**Exhibition of Environmental Assessment for the Integra Open Cut and Underground Coal Projects**

**Subject line: Integra Coal Integrated Development modification of project approval**

**INTEGRA OPEN CUT AND UNDERGROUND COAL PROJECTS – 75W MODIFICATION  
(08\_0101 Mod 1 and 08\_0102 Mod1)**

Complex overview

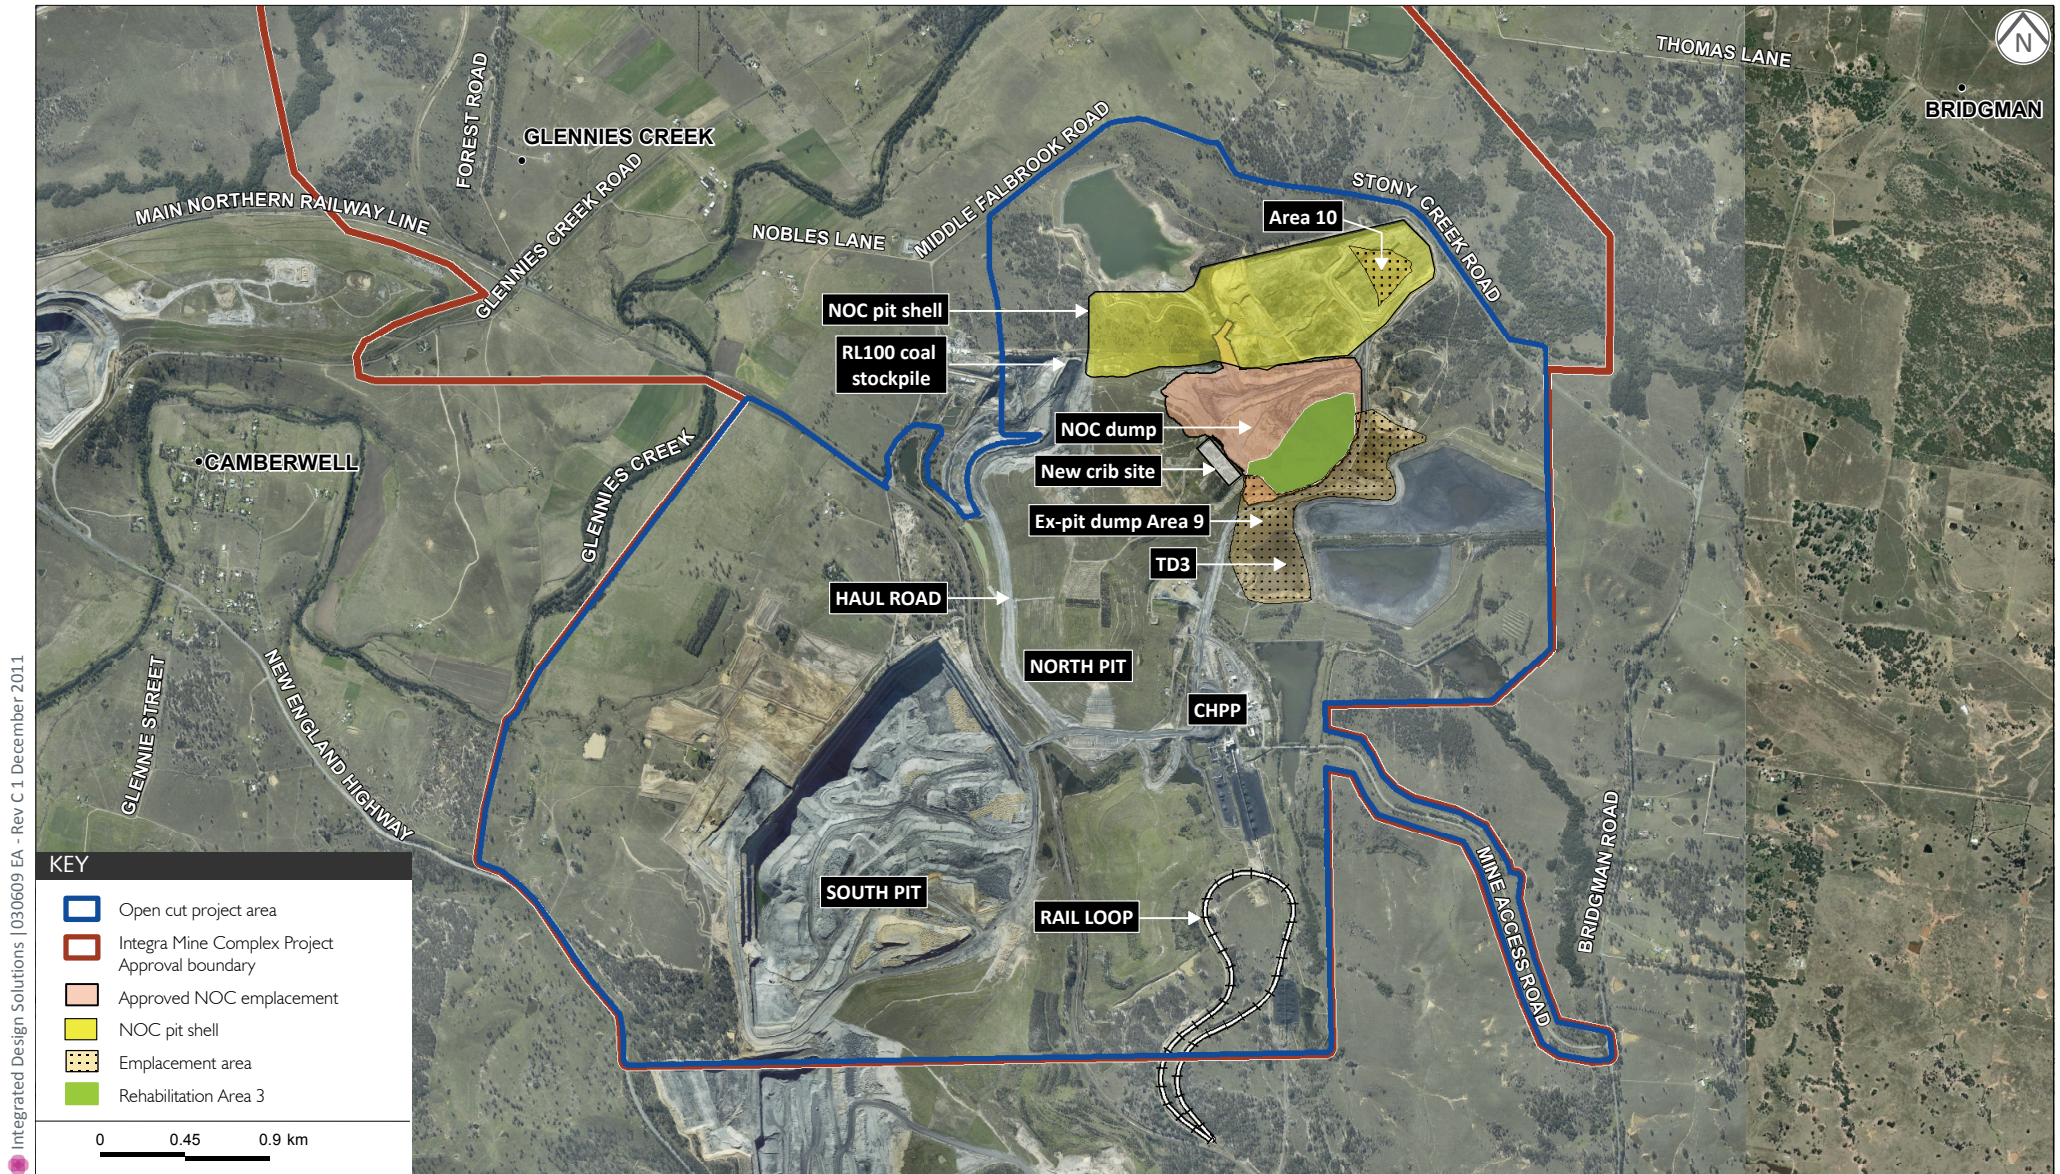
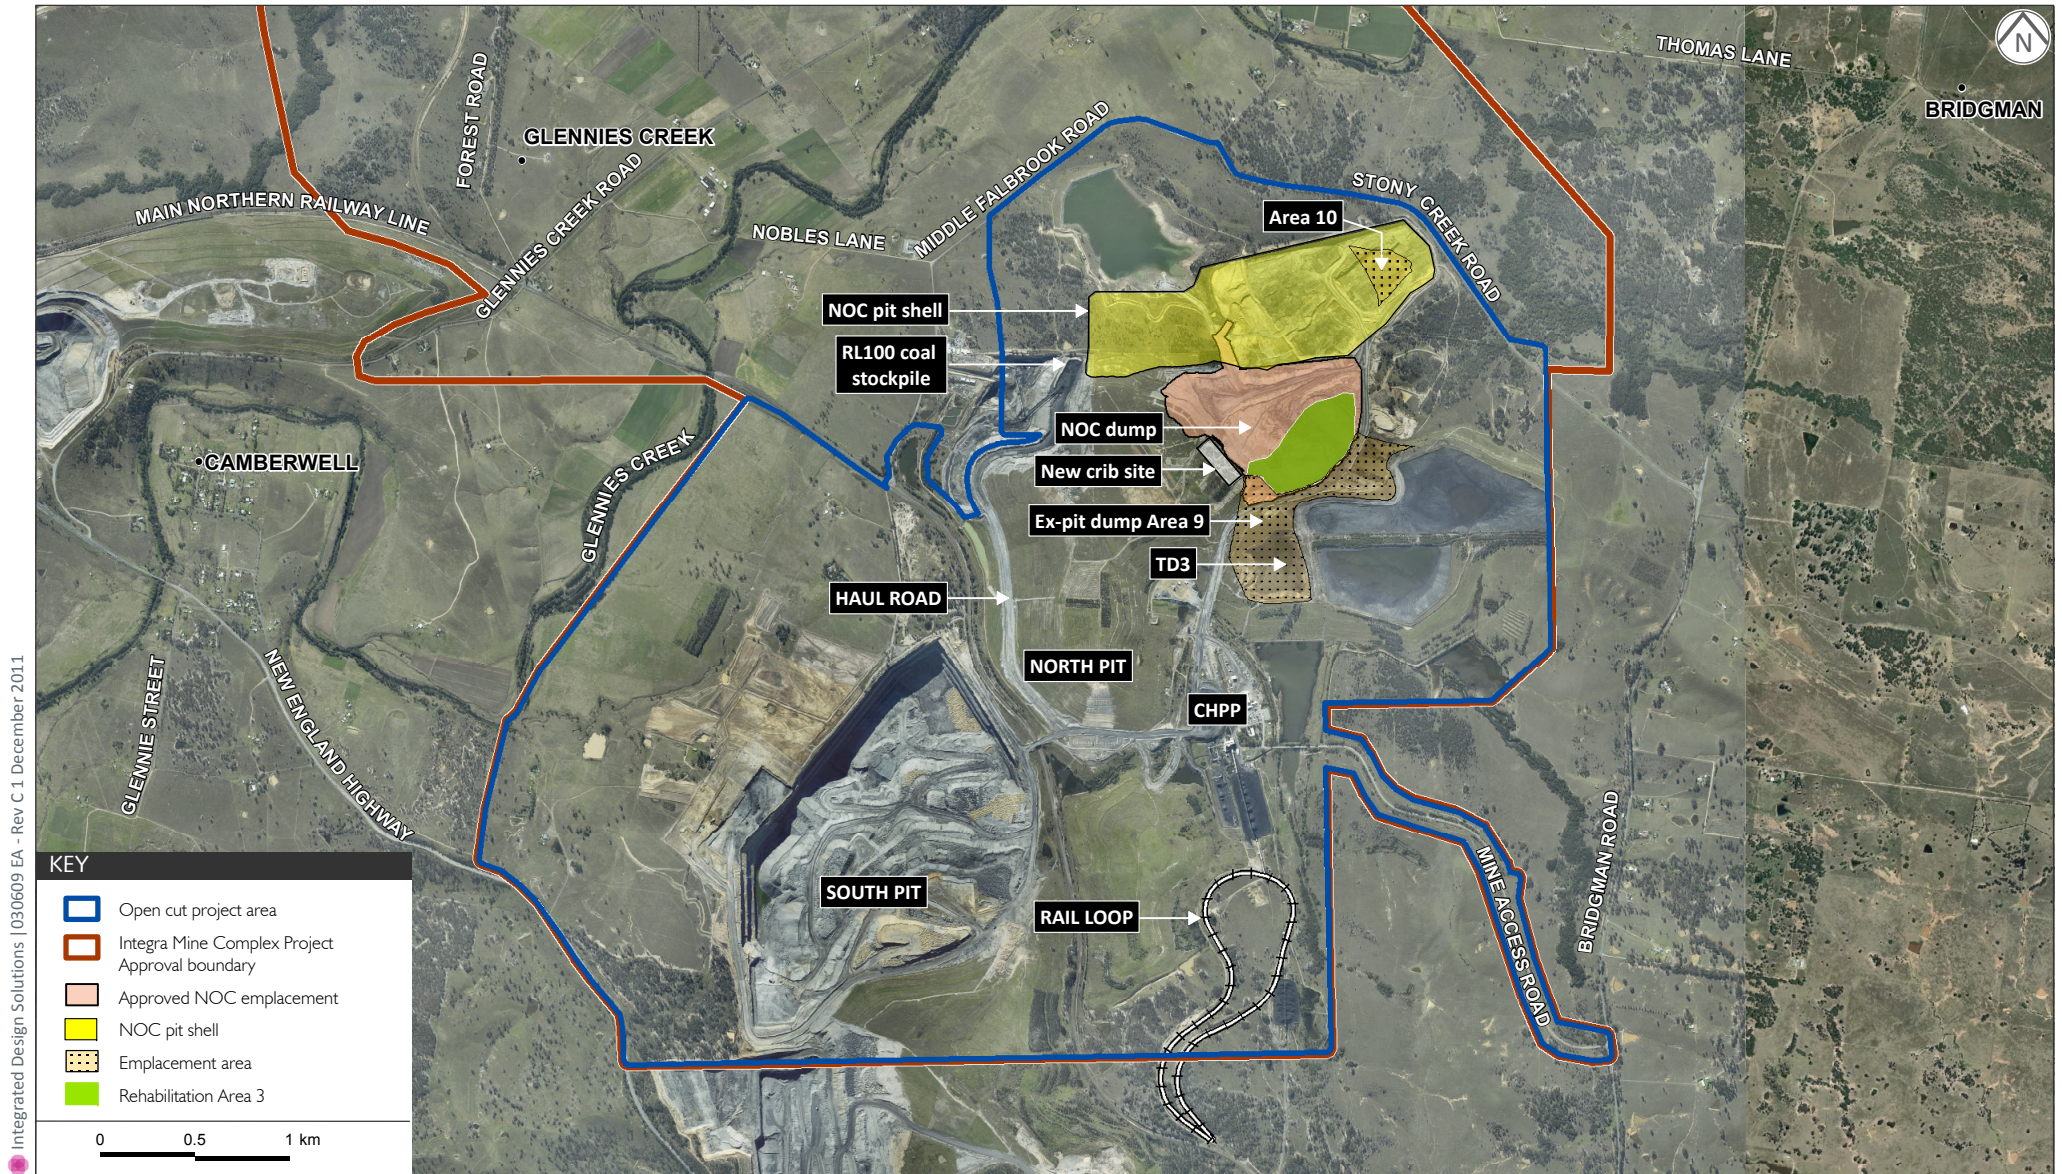
The modification to the North Open Cut Emplacement Strategy proposes to use ex-pit dump Area 9 for additional waste-rock emplacement with the intention to utilise the waste-rock in capping Tailings Dam 3. Figure 3.1 of the EA depicts the extent of ex-pit dump Area 9. It appears that the northern section of ex-pit dump Area 9 overlaps the southern portion of the Southern Biodiversity Offset area. The EPA does not support waste emplacement areas encroaching on areas already identified as biodiversity offset areas.

The proponent should clarify the extent of ex-pit dump Area 9 and confirm if it encroaches on the Southern Biodiversity Offset area. If encroachment is proposed, the proponent will need to identify measures to be employed to prevent impact on the Southern Biodiversity Offset Area.
